Planning Application No: 3/2021/0078

We wish to make you aware of a number of strong objections that we have with regards to the proposed rear extension of Mr and Mrs Kinder at 28 Beech Drive, application number referenced above.

PROPOSED REAR (W) ELEVATION
Scale 1:50

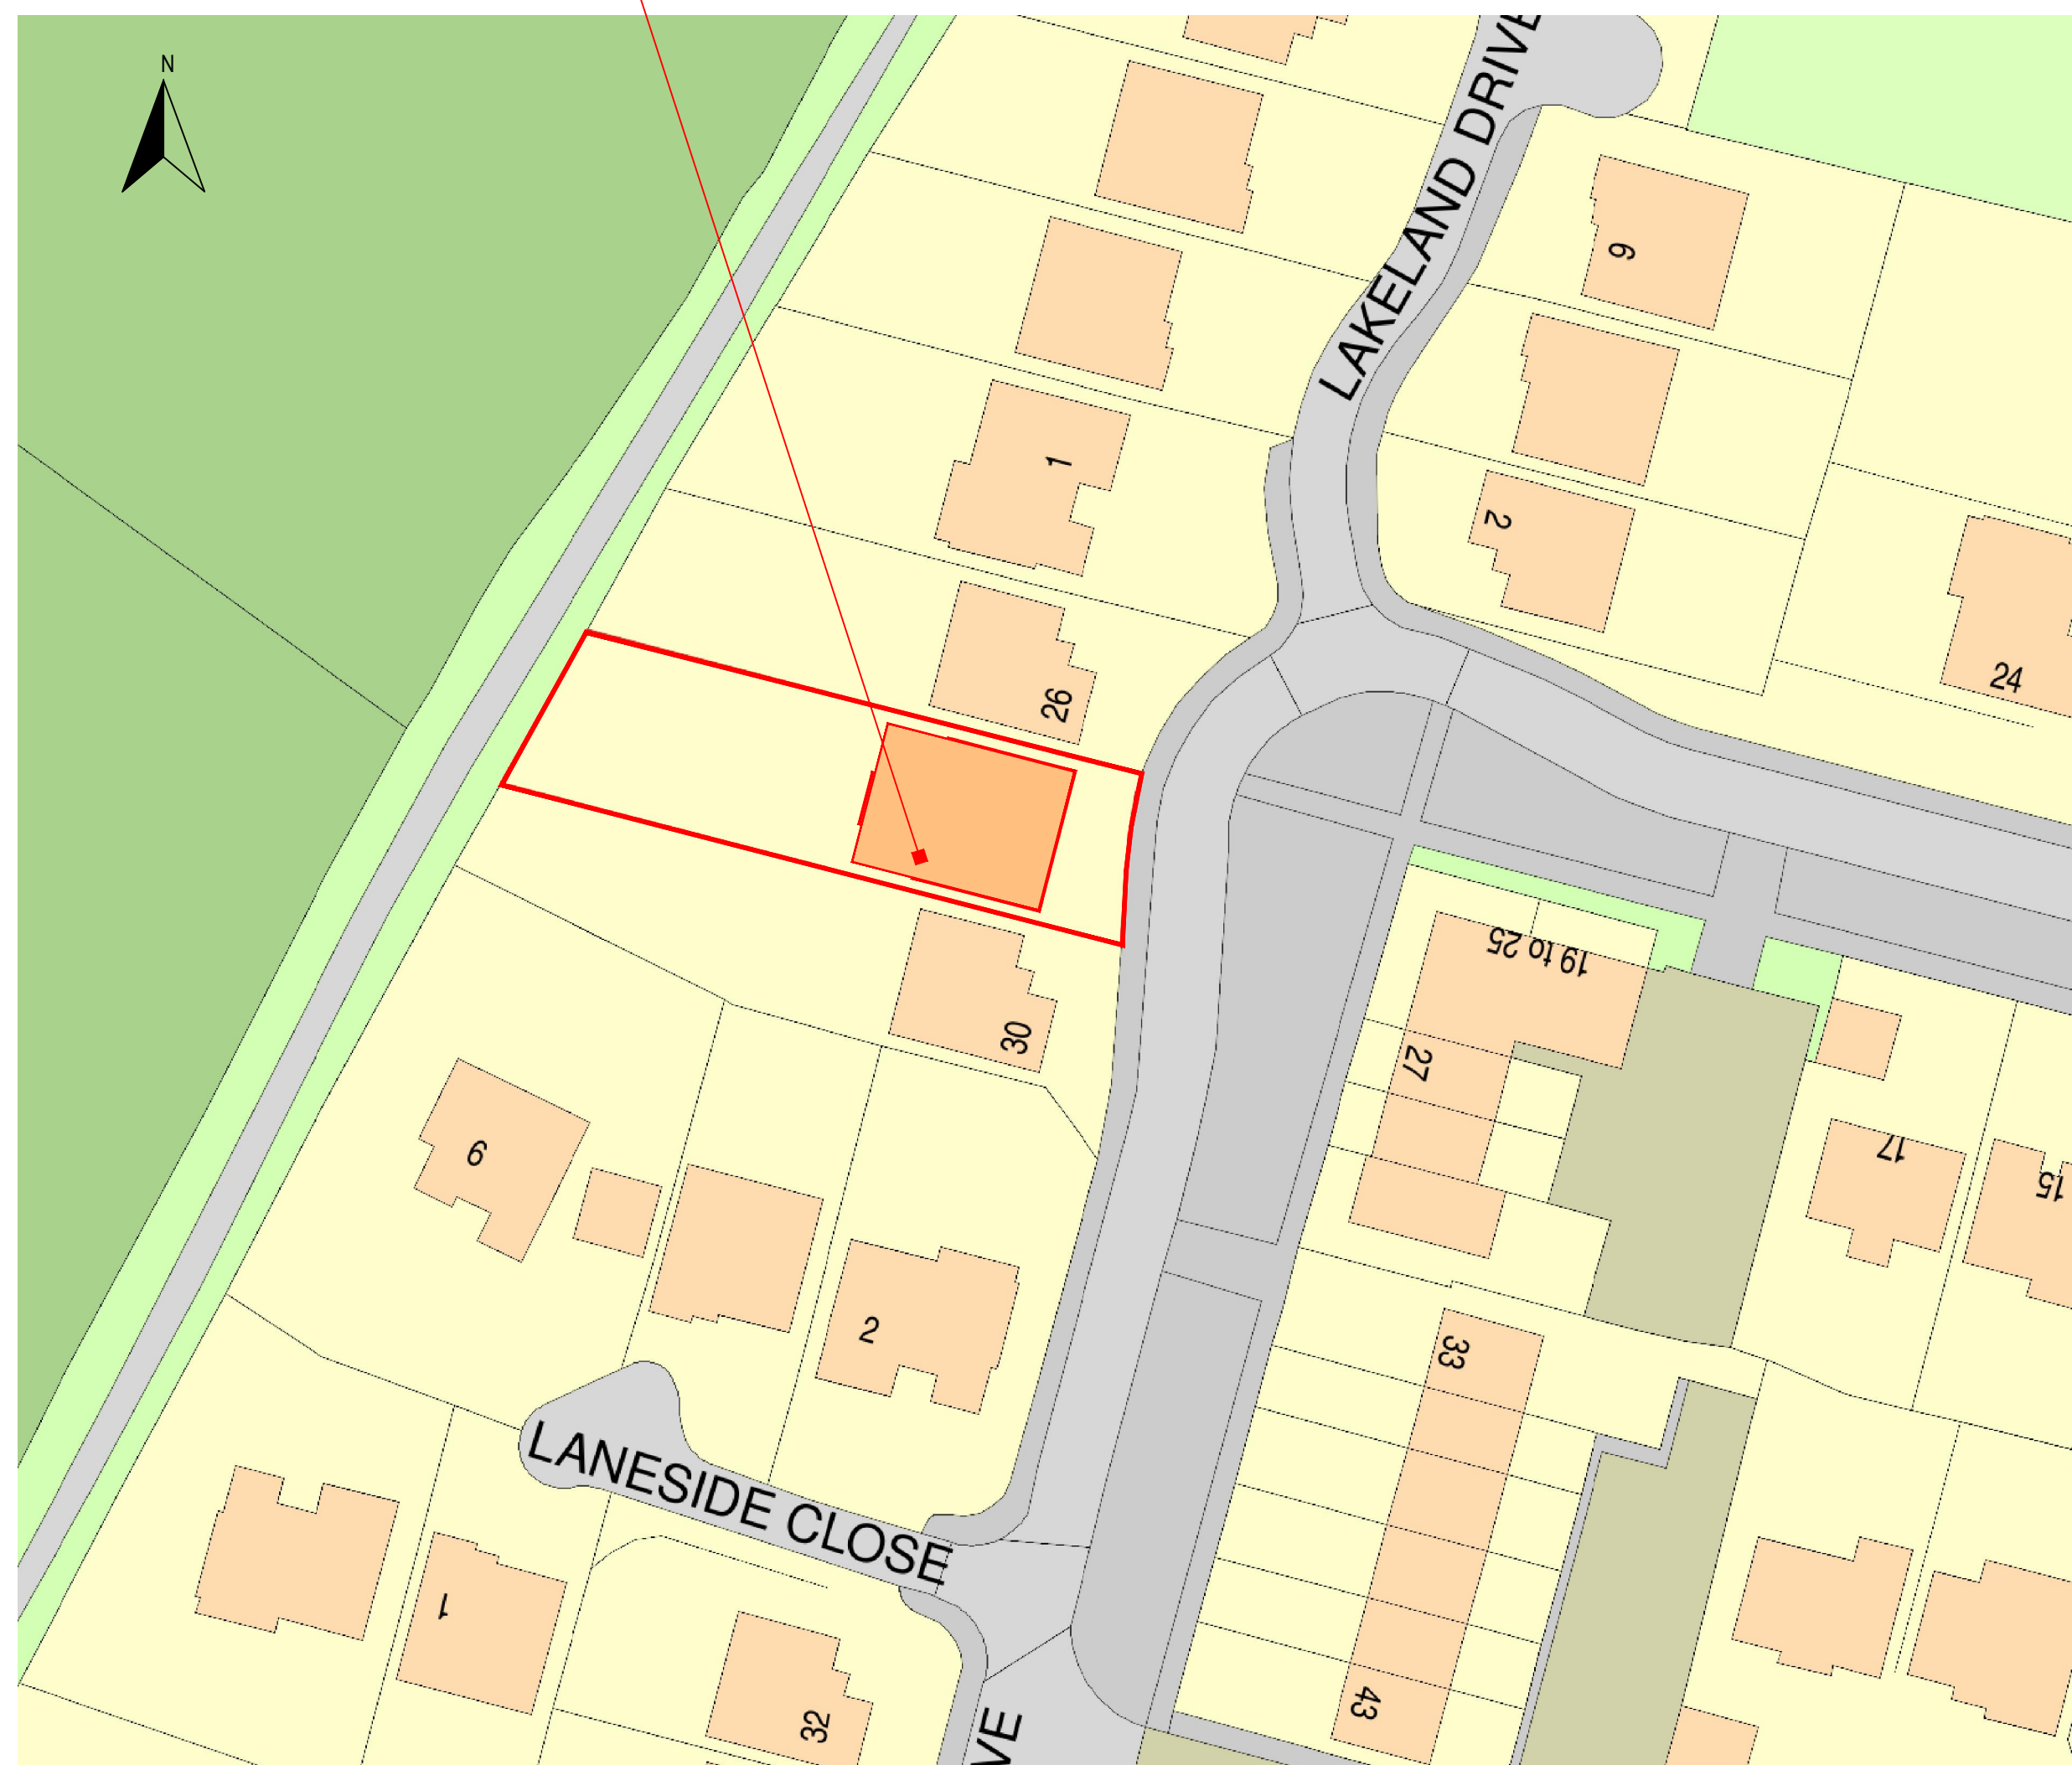
No other house on the Calderstones estate has such an extension which is planned by Mr and Mrs Kinder. The common extensions are ground floor extensions like the conservatory which is at the back of the house at 28 Beech Drive at the moment. Their planned extension is the full width of their house which is uncommon to any other extension on the estate. Also it is planned to be two floors which includes a roof terrace. This shows that the proposed extension is out-of-scale compared with existing houses in the vicinity.

The proposed extension, by reason of its size and sitting, represents an un-neighbourly form of house extension that would have an disagreeable impact on the amenity of neighbouring properties by reason of an overbearing effect.

This is not correct because to implement the planned extension there is a hedge that would need to be removed. This hedge is currently on the property of 28 Beech Drive straight next to the fence [REDACTED]

The side wall of the ground floor extension and the additional wall on the terrace (they call it "screening" on their application) [REDACTED] This is a massive loss of our existing view and adversely affects the residential attractiveness of the neighbouring owners.

Our neighbours plan of their rear extension also includes a roof terrace. This would mean a clear loss of privacy [REDACTED] At present our garden cannot be overlooked from any other neighbours while they are sitting in their garden or on their patio. With any type of outside area on the first floor the neighbour of 28 Beech Drive can overlook our garden from the front of their terrace. Additionally and also distressingly they could even look into parts of our lounge.
